**REQUEST**

Current Zoning: N1-A (neighborhood 1-A)  
Proposed Zoning: UR-2(CD) (urban residential, conditional)

Approximately 9.23 acres located on the east side of Mallard Creek Road, north of Galloway Road, and west of Tavernay Parkway.

The petition proposes a residential community of up to 72 70 multi-family attached townhome style dwelling units together with accessory uses.

**RZ-2**

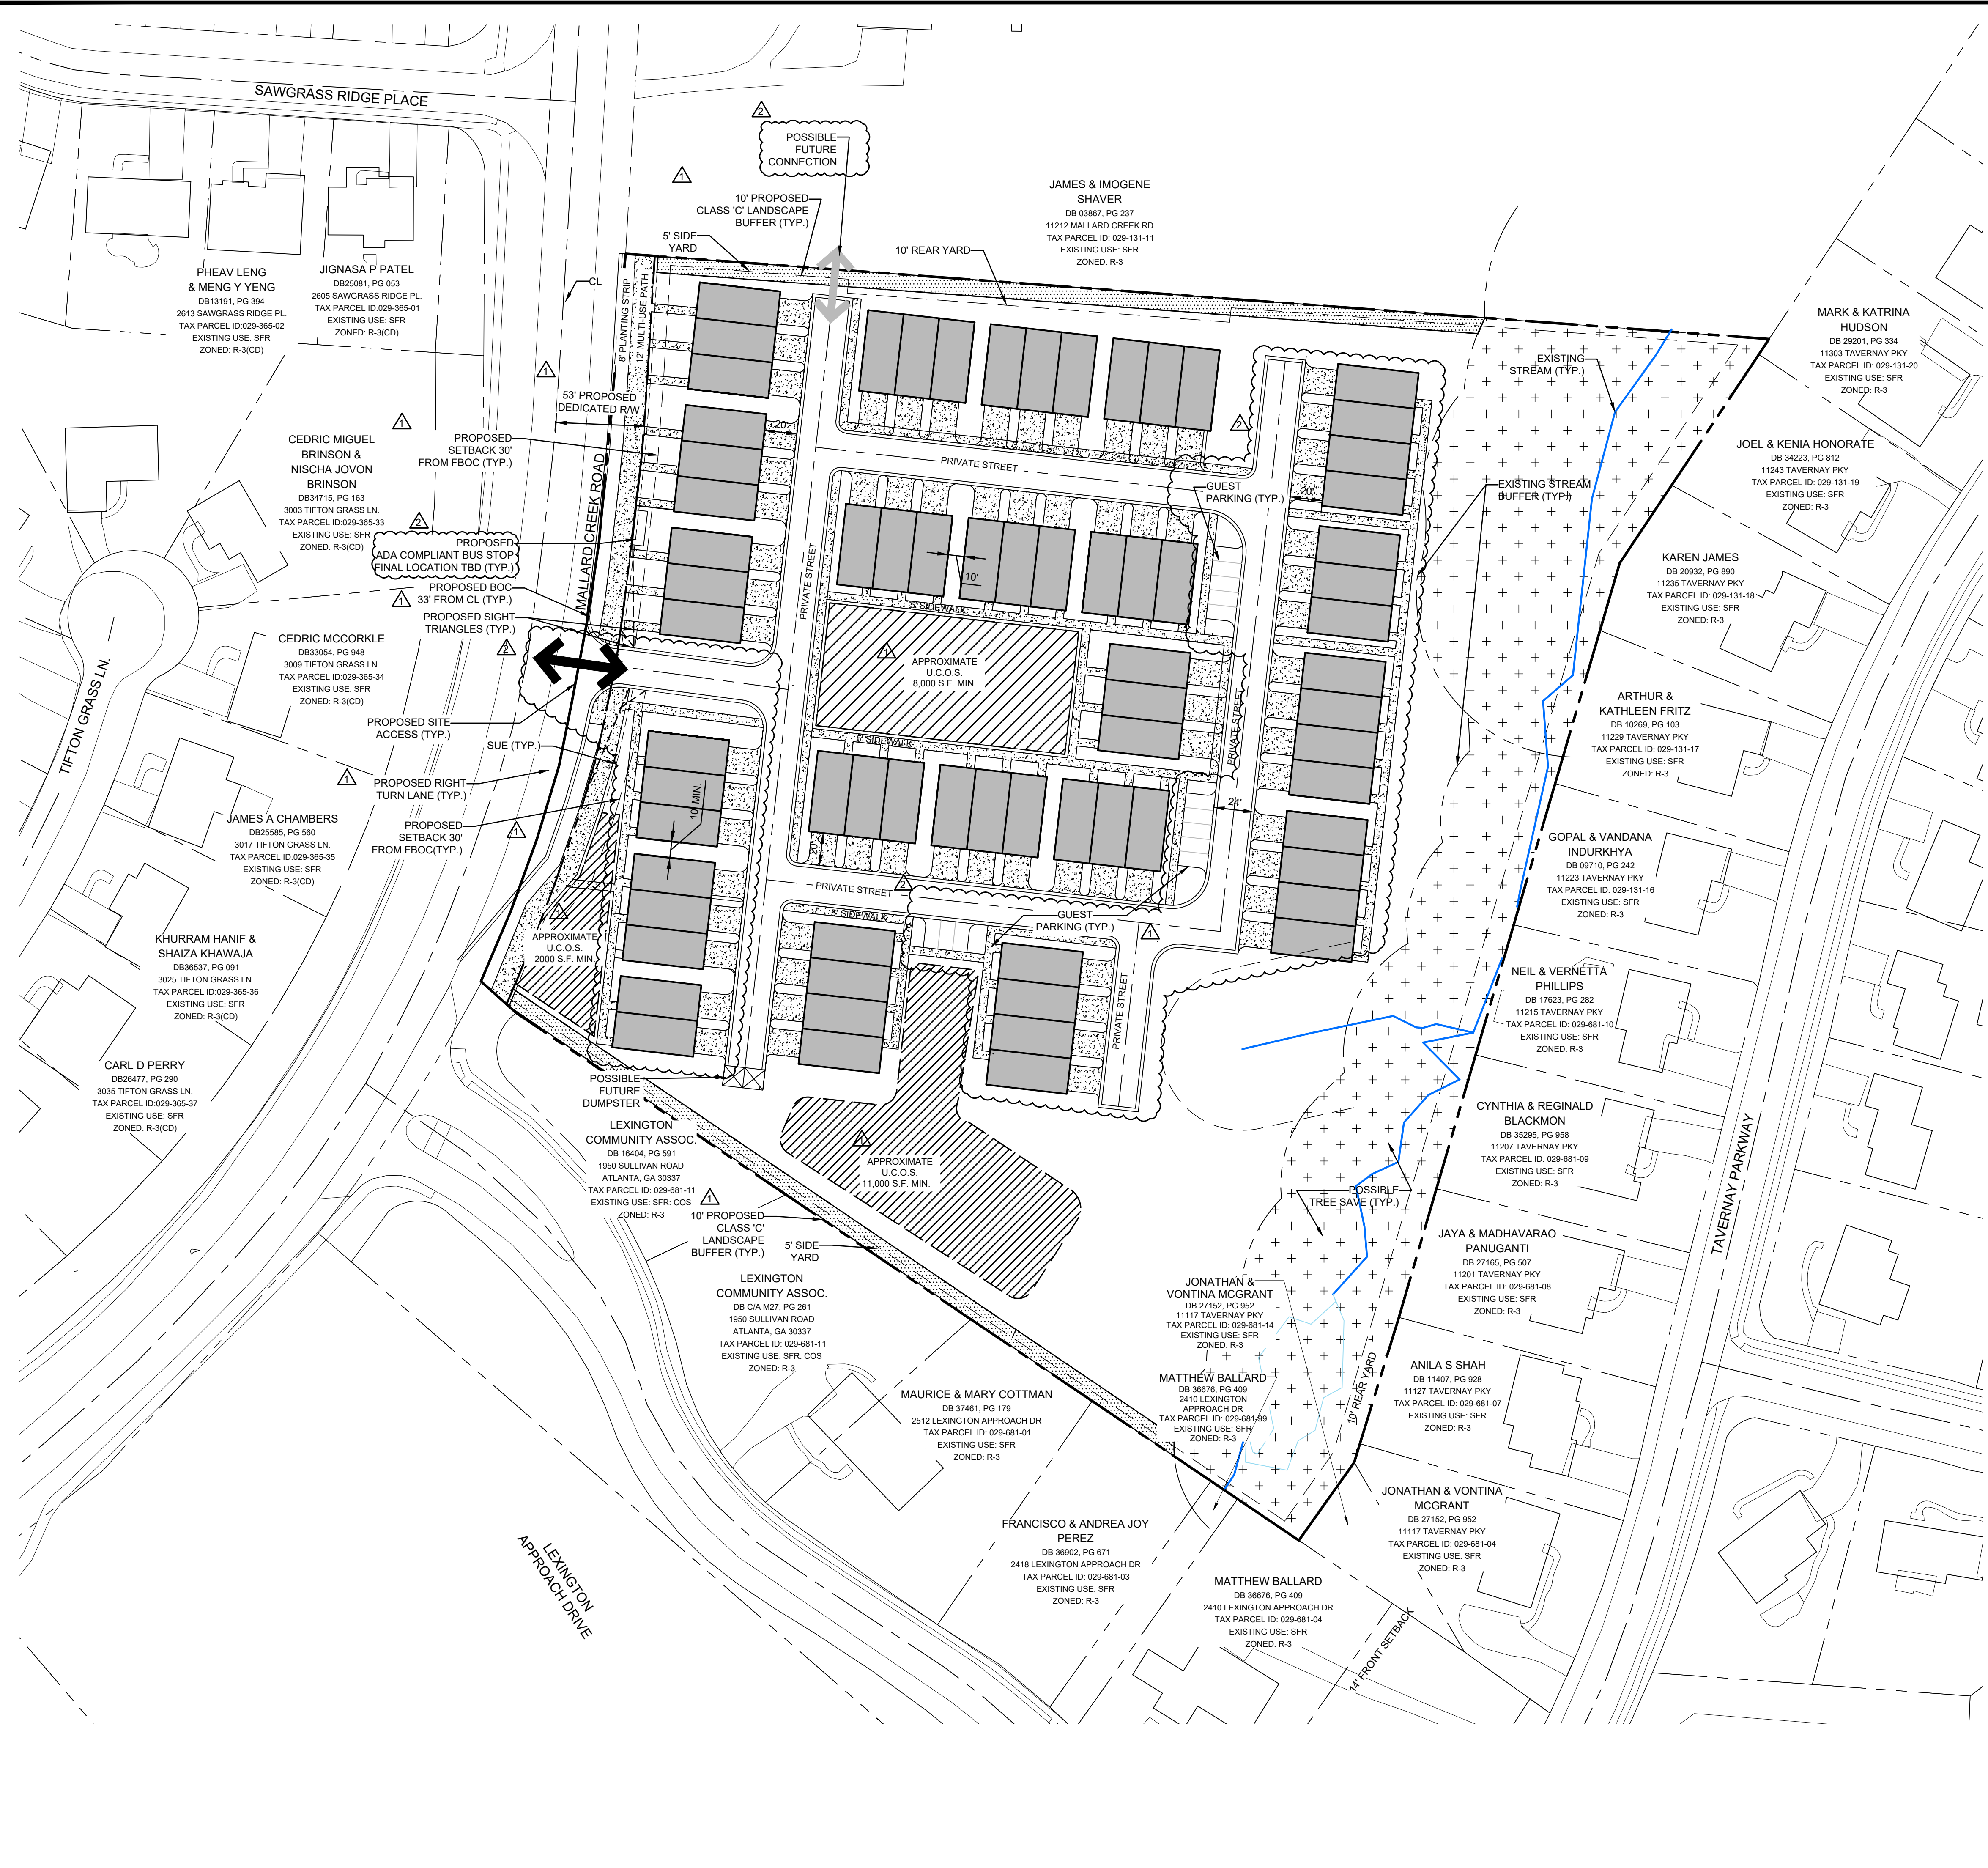
1. The site is served by CATS bus route #54. CATS requests the construction of ADA compliant bus standard detail 60.02A, 50 feet beyond the development entrance. The final location will be coordinated with the developer during the Land Development plan review process. Addressed
2. Site and Building Design
3. Reduce unit count and number of buildings with a mix of single family, duplexes, and triplexes to be consistent with the Neighborhood 1 Place Type. Addressed
4. Limit architectural note 5 to a maximum of 3 units per building along Mallard Creek Road. Addressed
5. Provide visitor parking spaces. Addressed
6. Limit height to 40 feet. Addressed
7. Add a street connection to the parcel to the north. Addressed
